#### 21/00922/OUT

# Land West of Foxden Way Great Bourton OX17 1QY

**Proposal:** OUTLINE Planning Application with all matters reserved save for access for

up to 9 First Homes

TITLE
PROPOSED SITE ACCESS JUNCTION WITH VISIBILITY SPLAYS

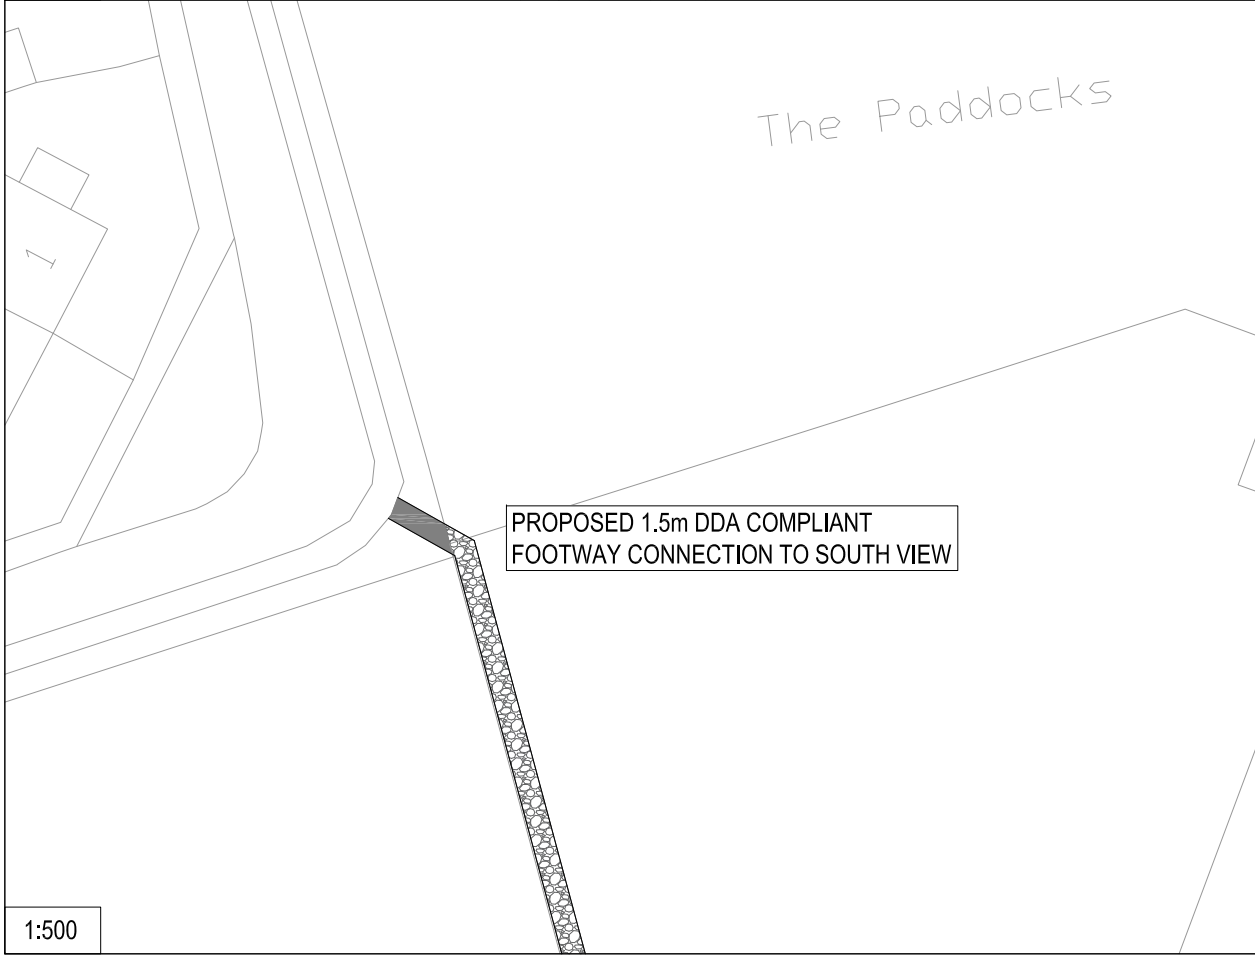
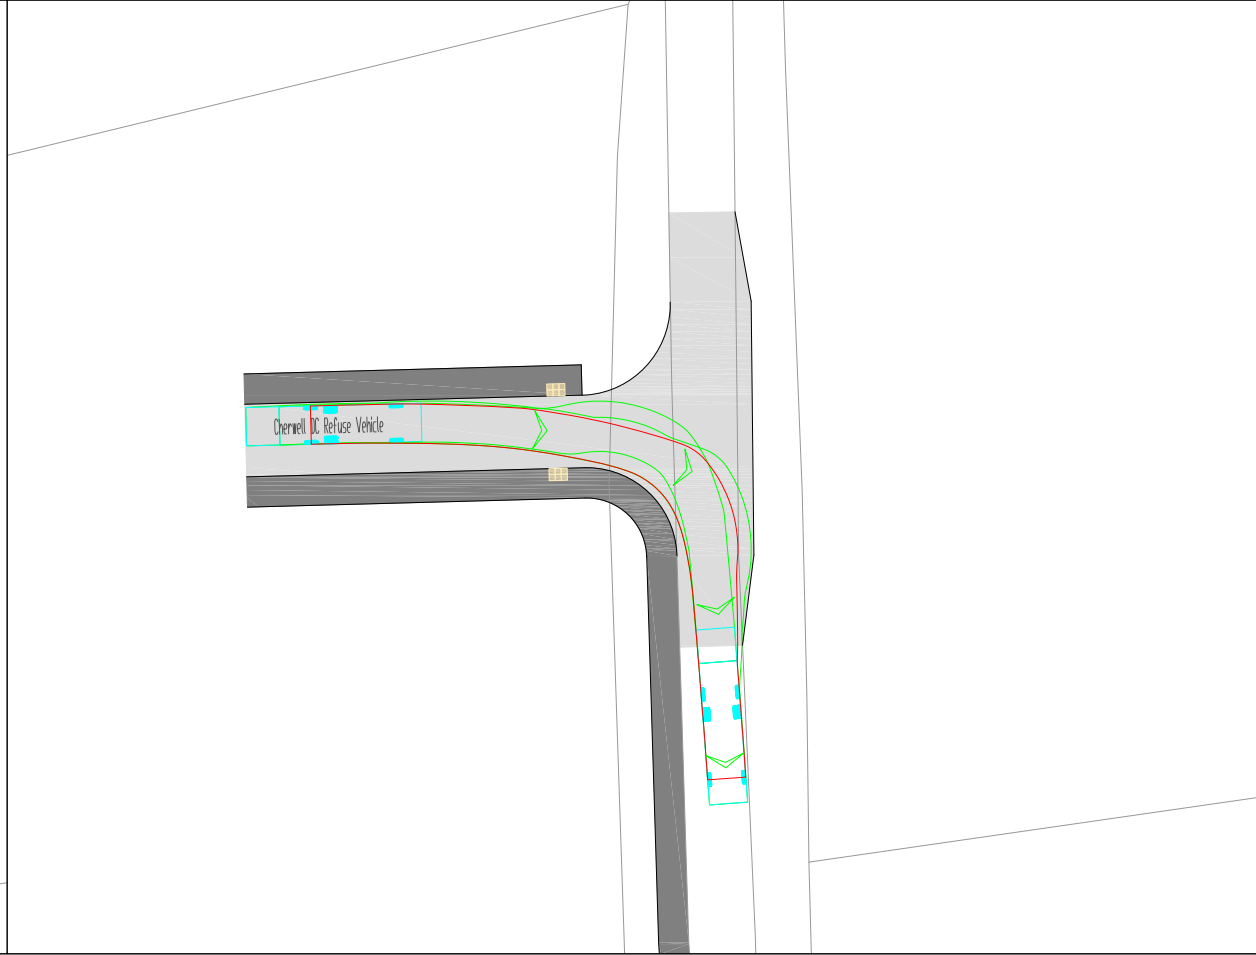
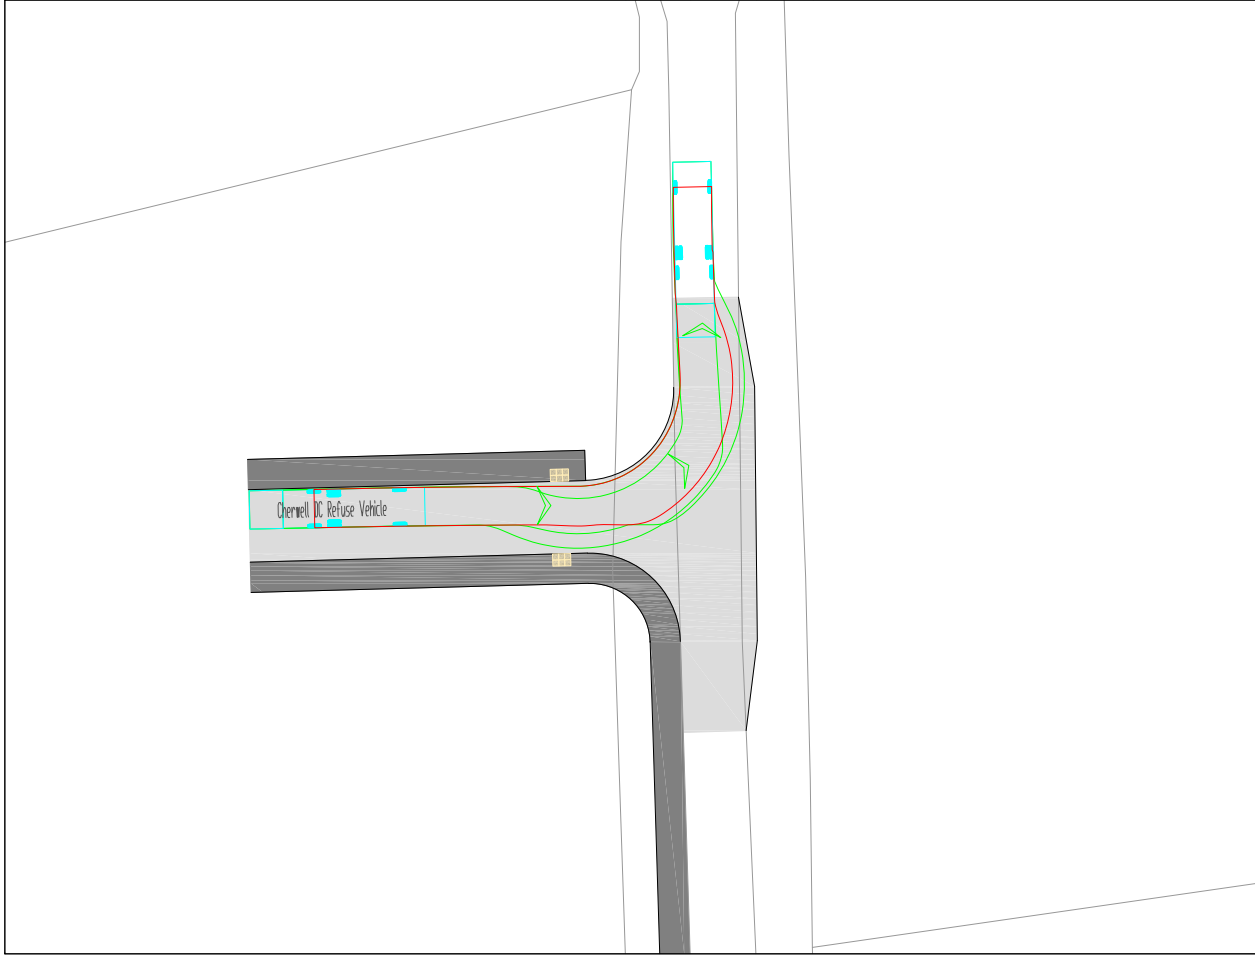
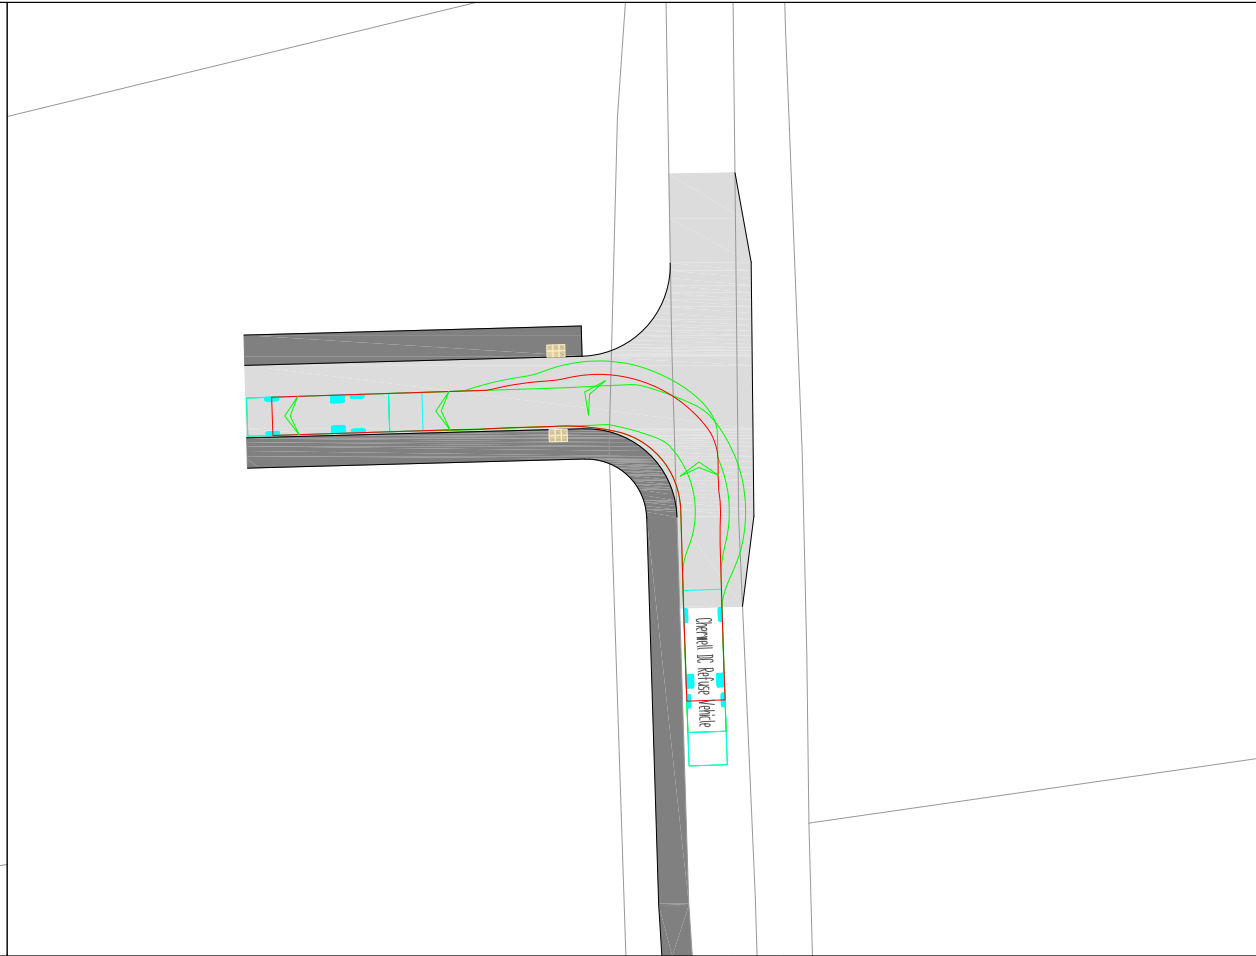
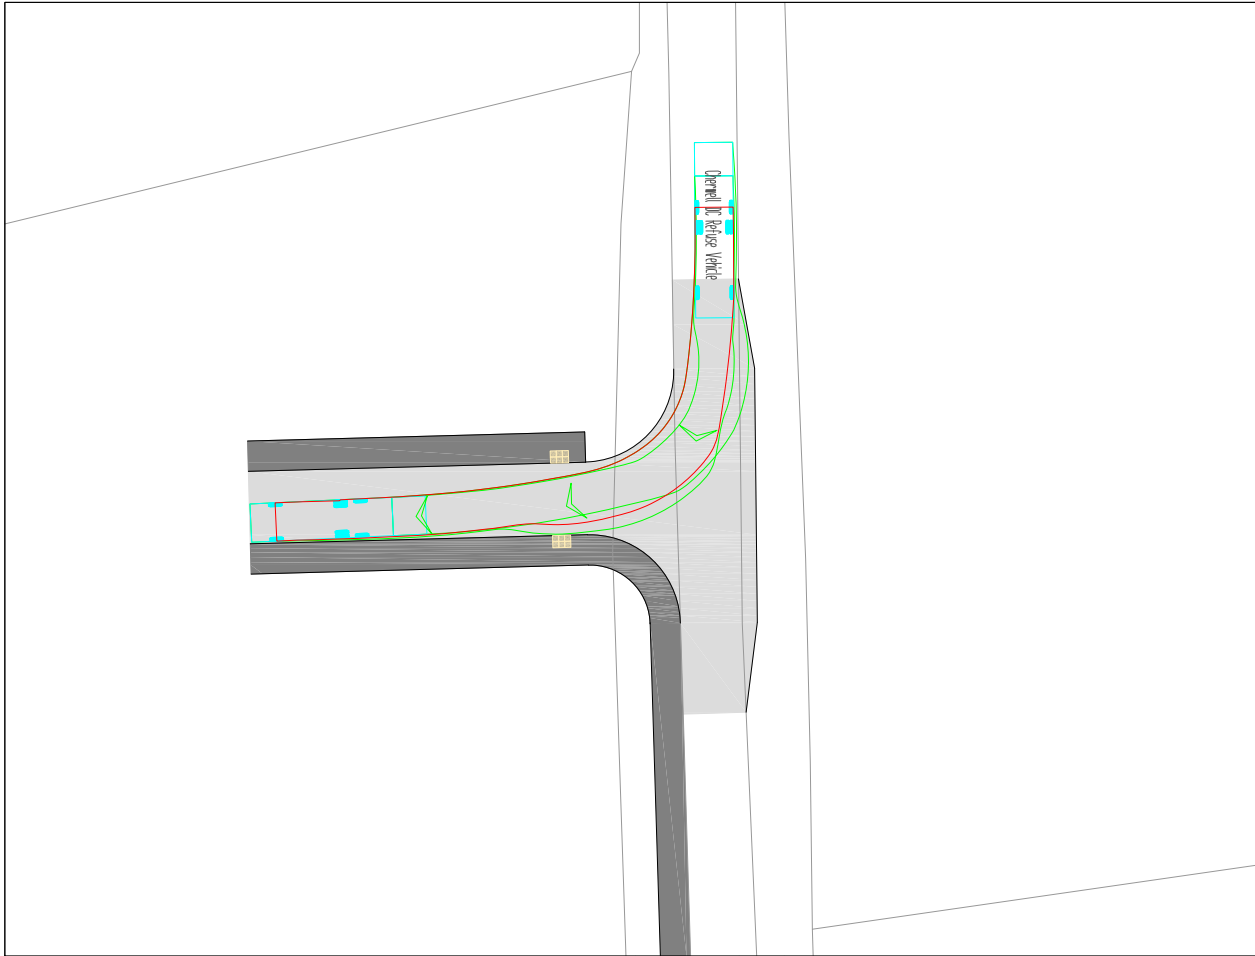
- 7.25. OCC HIGHWAYS: Originally objected to the proposal raising concerns about the delivery of the footpath connection to South View (not in the red line) and pedestrian connectivity, the reliability of the automatic traffic counts, concerns regarding the extent of the visibility splays, servicing arrangements for refuge vehicles, concerns over large construction vehicles using School Lane in Great Bourton and Spring Land in Little Bourton. Requested details to show that Crow Lane and Main Street will be able to accommodate construction vehicles. Also raised concerns regarding the locational sustainability of the village, access to services and facilities and lack of public transport option.

- 7.26. Further to the receipt of additional and amended information raises **no objections** subject to conditions. The vision splays are considered to be acceptable and the swept path analysis should that a refuse vehicle can access and egress the site. The vehicle overrun issue is resolved through the localised widening of Foxden Way at

the site access. Full details of the construction access can be provided in a Construction Traffic Management Plan. The previous plans made no provision for additional pedestrian infrastructure. The plans now show a 2m [this was corrected with OCC Highways to confirm proposal is for 1.5m] path along Foxden Way to the allotments and an additional pedestrian access to South View. If a 2m width is not achievable, further details should be provided demonstrating the new path isn't bordered by obstacles. Full details of this should be secure through condition and it should be a suitable width and material. The applicant will need to enter into a legal agreement with OCC prior to undertaking any works on the highway.

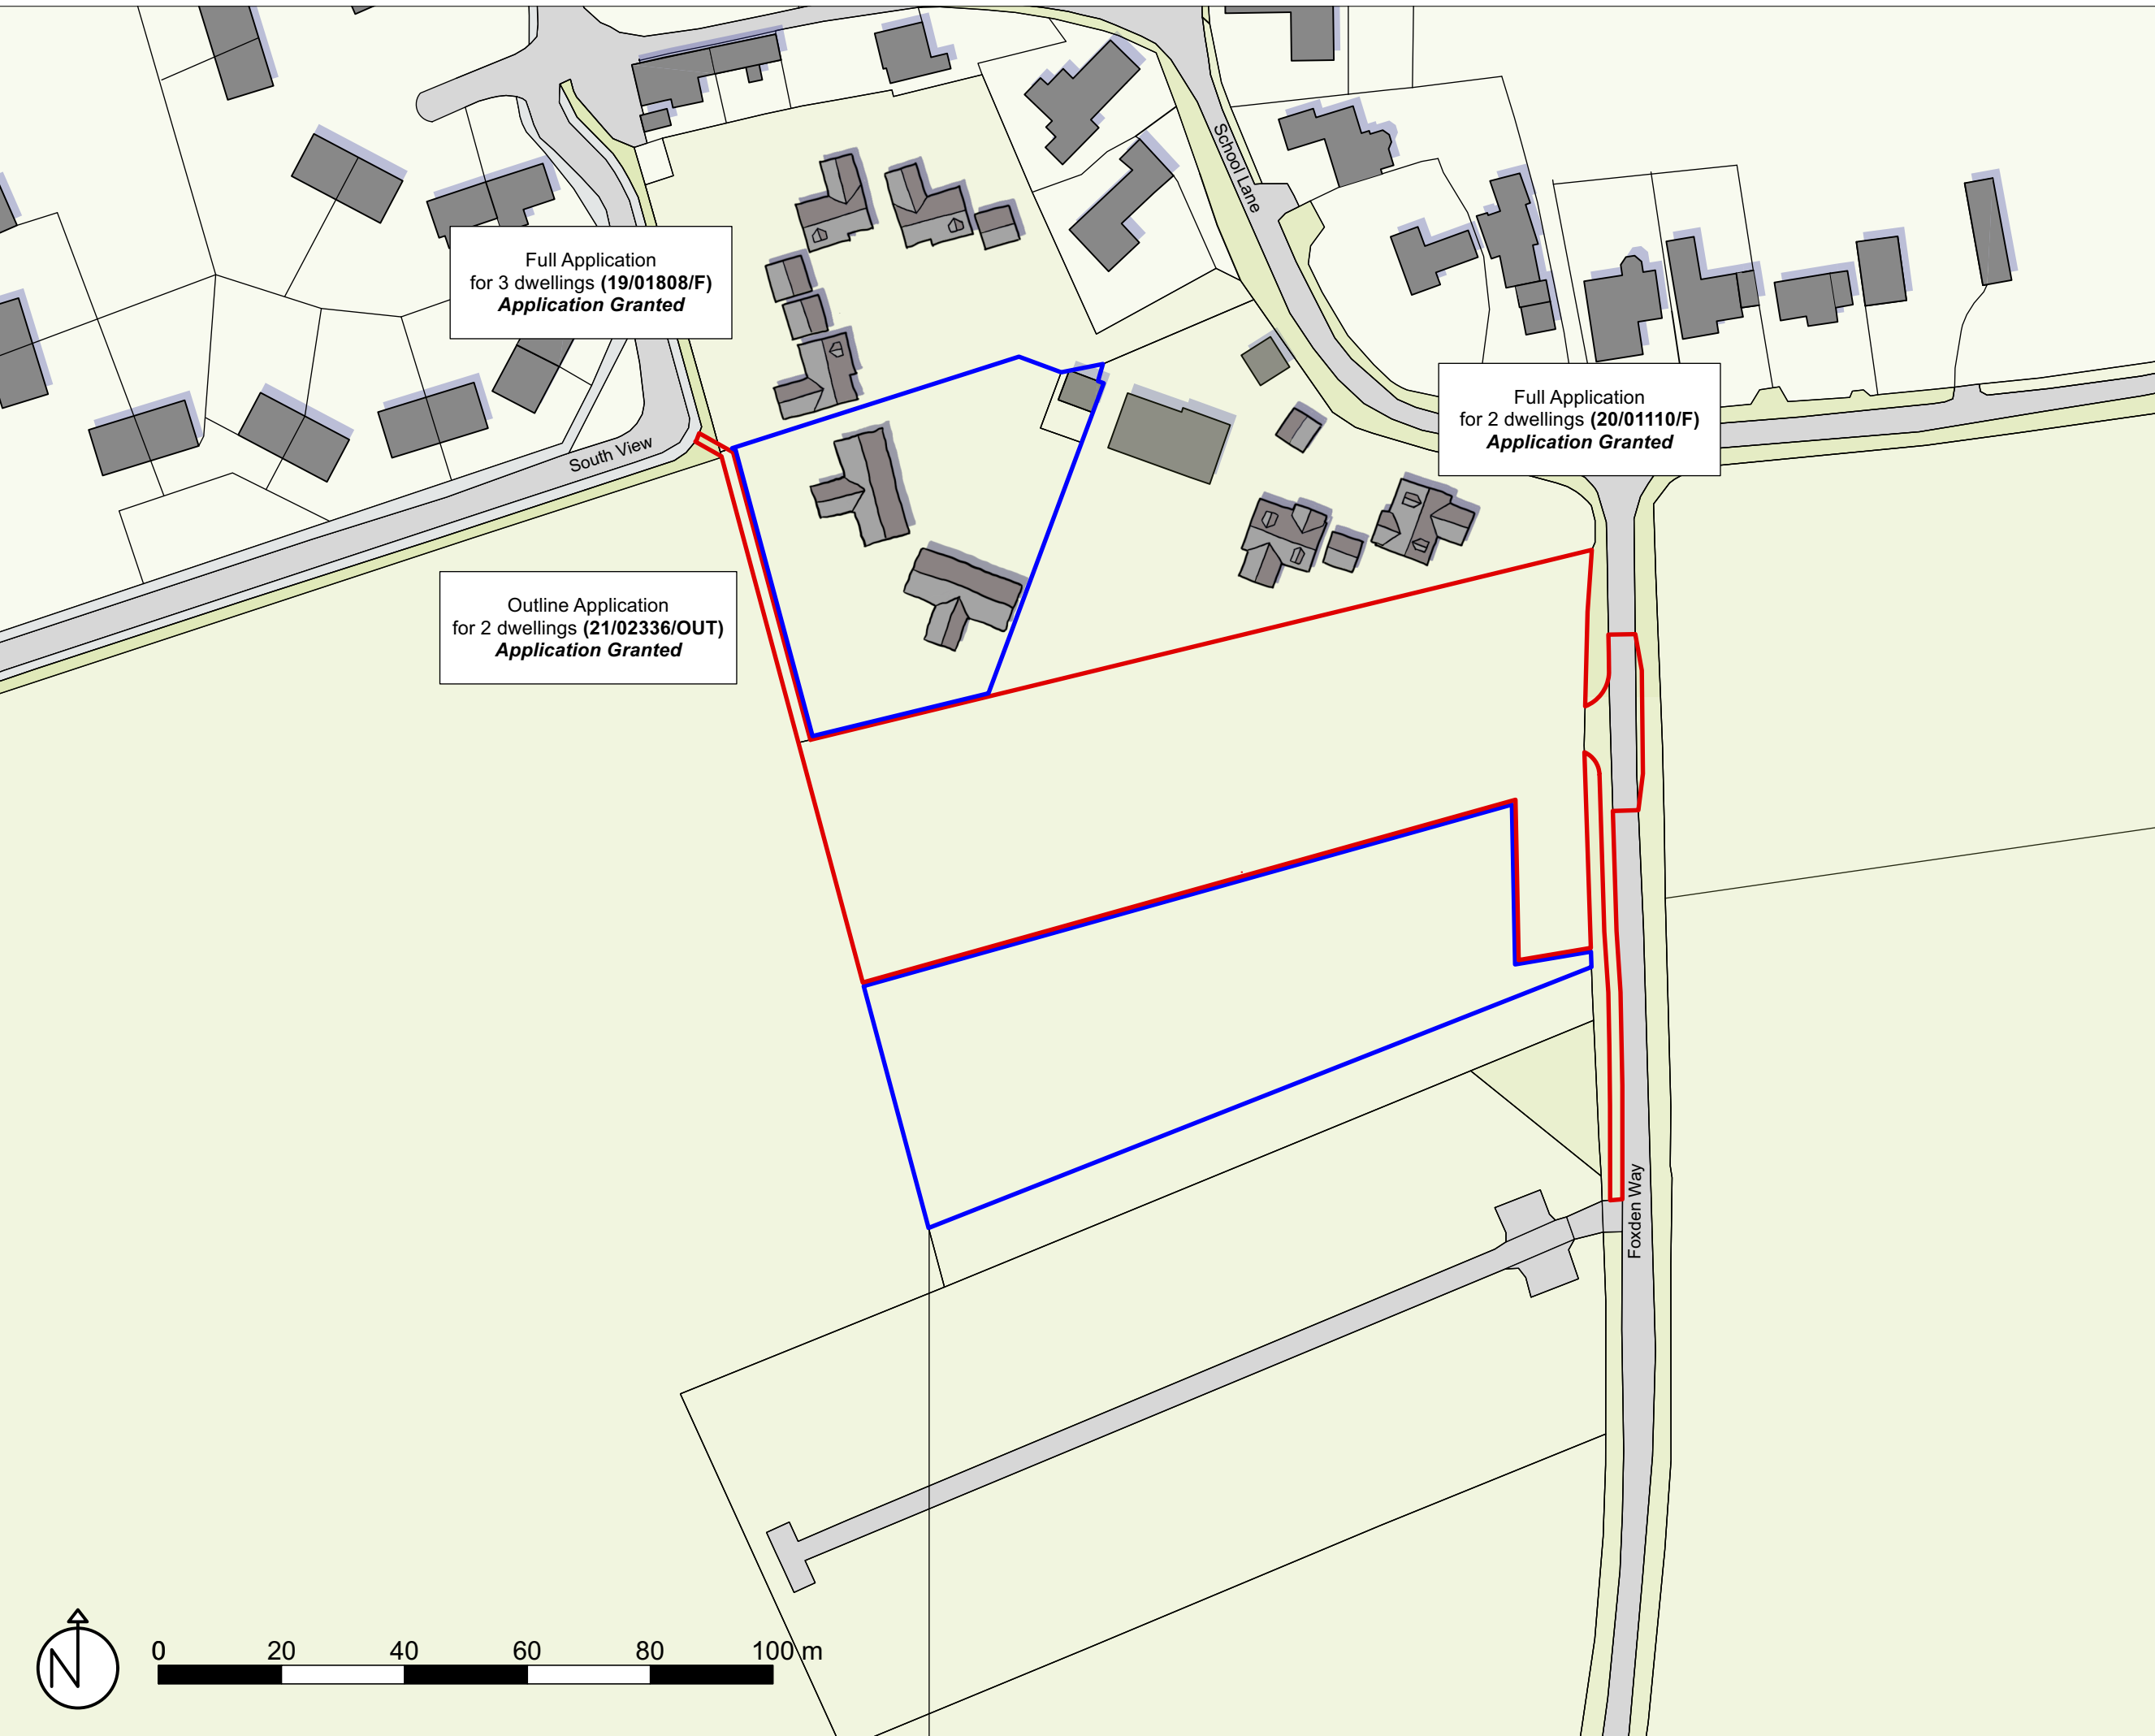
The LVA suggested a layout which provided an 'appropriate and sensitive transition between the proposed development and the wider landscape' 'with a positive outward looking approach to the east, south and west' A layout like this was proposed in the D&A statement but has now been abandoned.

The layout submitted allows for further dwellings to the south to be built at a later date. These dwellings will have rear gardens backing onto open countryside which is not a positive outward looking approach. Rear gardens with all their domestic additions do not provide for an attractive or sympathetic rural edge. There is nothing in the D&A statement which gives any indication of the design quality of the scheme.
